Rezoning Transportation Analysis
Petition Number: Insert Zoning Petition #2021-198
General Location Identifier: Tax ID 18712322

Revision Log:

Date	Description
12-28-21	First Review (WB)

Rezoning Transportation Analysis

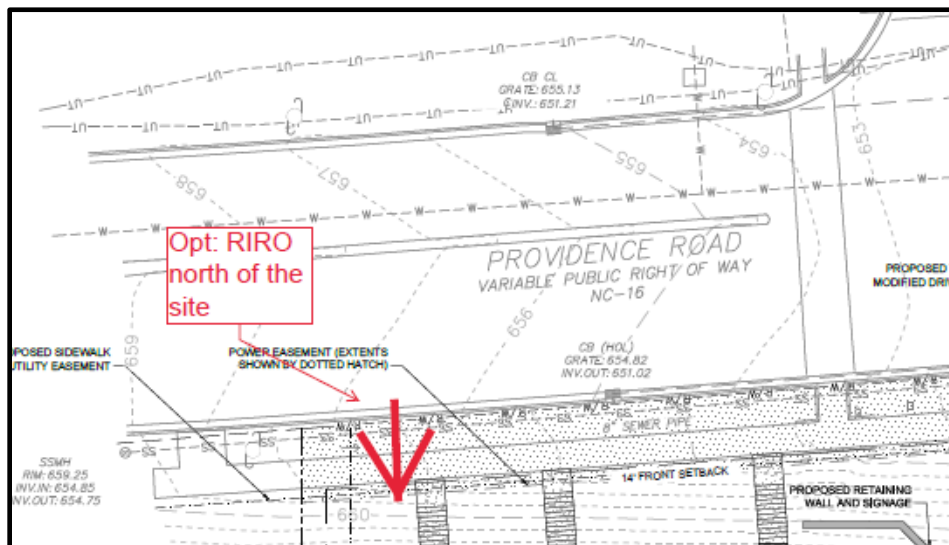
Providence Road: The future curb line will be located 41' from the center line to the back of curb; however, the curb line will remain in its current location.

Label and dimension the existing and future curb and gutter from the centerline for each road on the site plan.

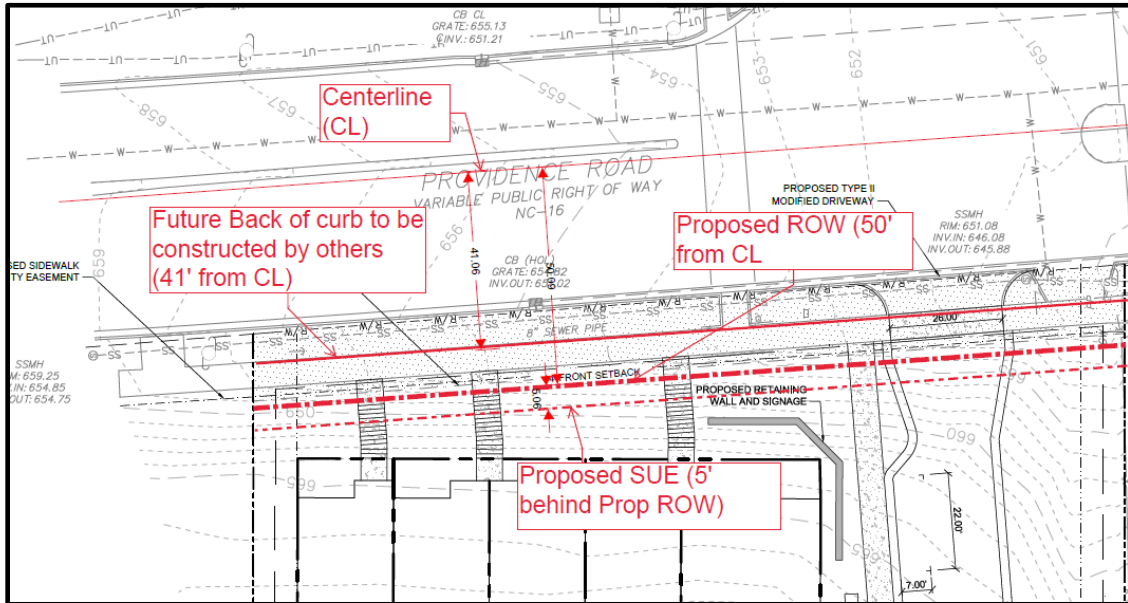
4. Revise site plan and conditional notes to commit to dedicate 50-foot right-of-way from the Providence Road centerline. The site plan shall label and dimension the right-of-way from the road centerline. (refer to Note 6. figure)

REZONING PETITION 2021-198

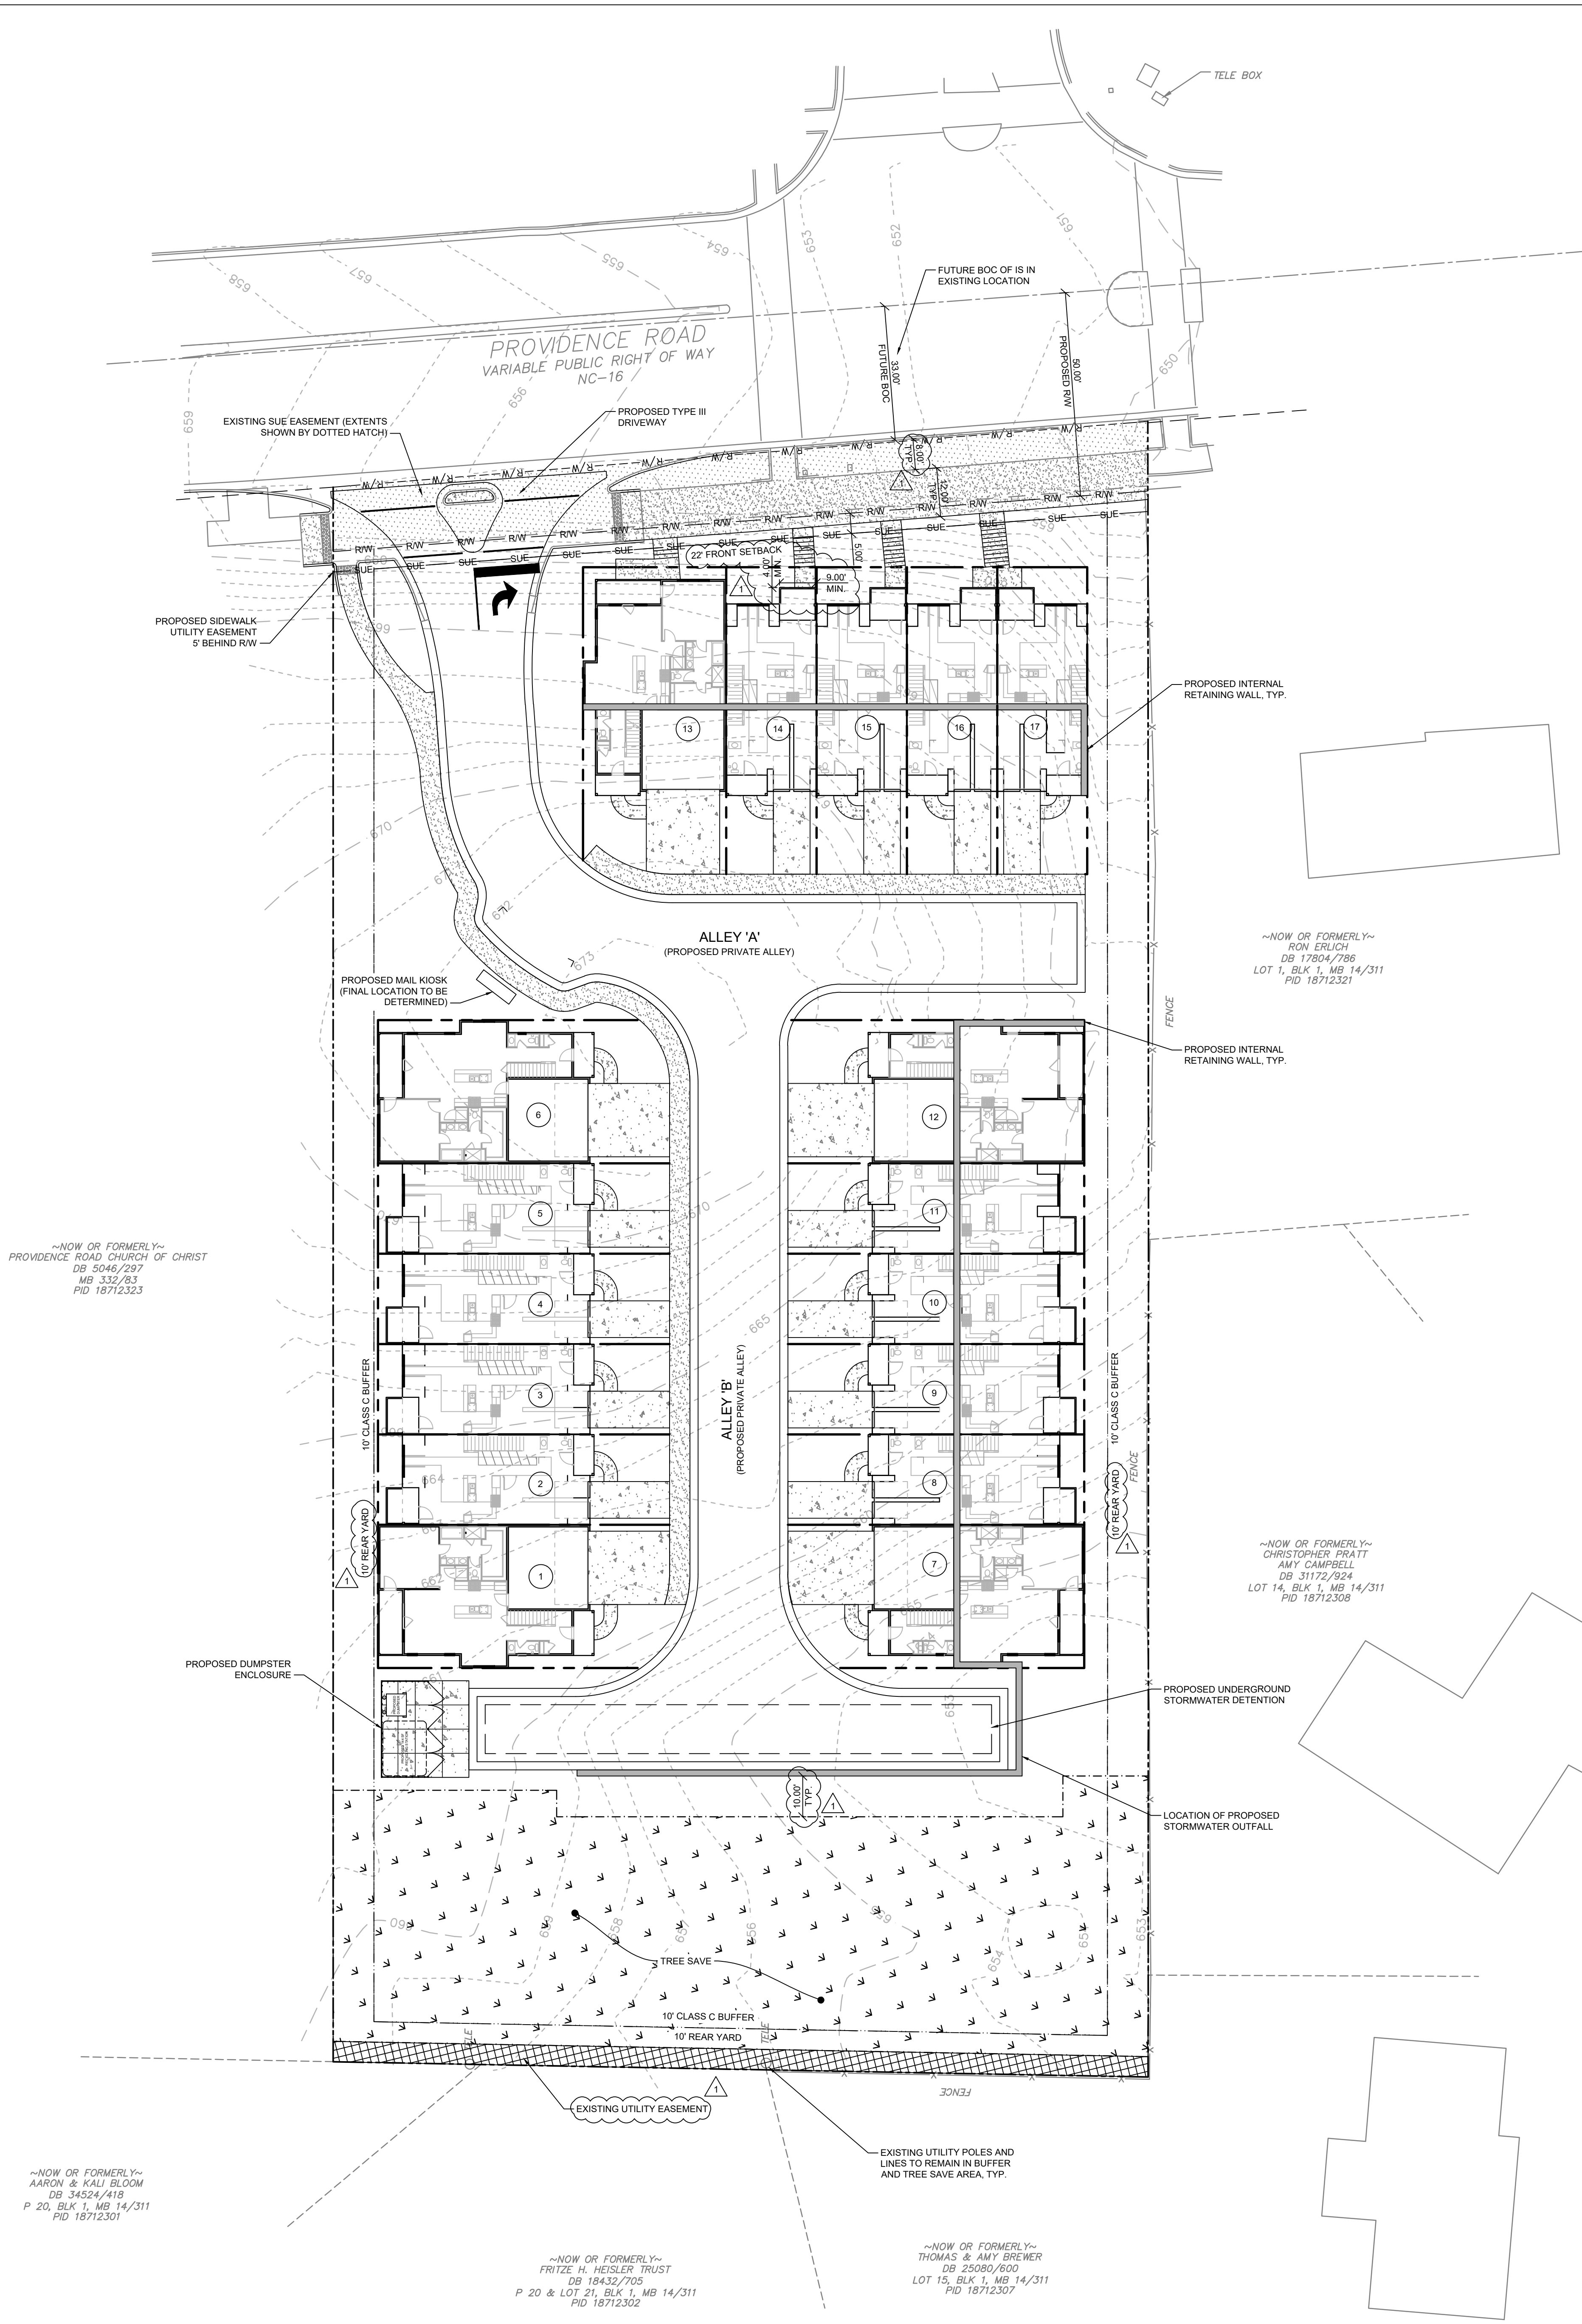
3. NCDOT will not allow this private driveway to have full access at this existing signalized intersection. NCDOT recommends a right-in-right-out (RIRO) limited access north of the signalized intersection.

5. Site plan and conditional notes revisions are needed to commit to construct bicycle facilities by installing a 12' multi-use path with an 8' planting strip to meet the City Charlotte BIKES Policy.
6. Revise site plan and conditional notes to commit to dedicate 5-foot sidewalk utility easement measured from the proposed right-of-way. CDOT requests that no steps be located within the SUE as the future sidewalk will be constructed therein. The site plan shall label and dimension the SUE from the proposed right-of-way.

7. Revise site plan to identify the location and container type for waste collection. Maneuvering not permitted in right-of-way or setback. Site plan design must accommodate Ingress/egress maneuvering path of design vehicles.
8. Revise Conditional note to reference the Providence Road, not North Davidson Street.
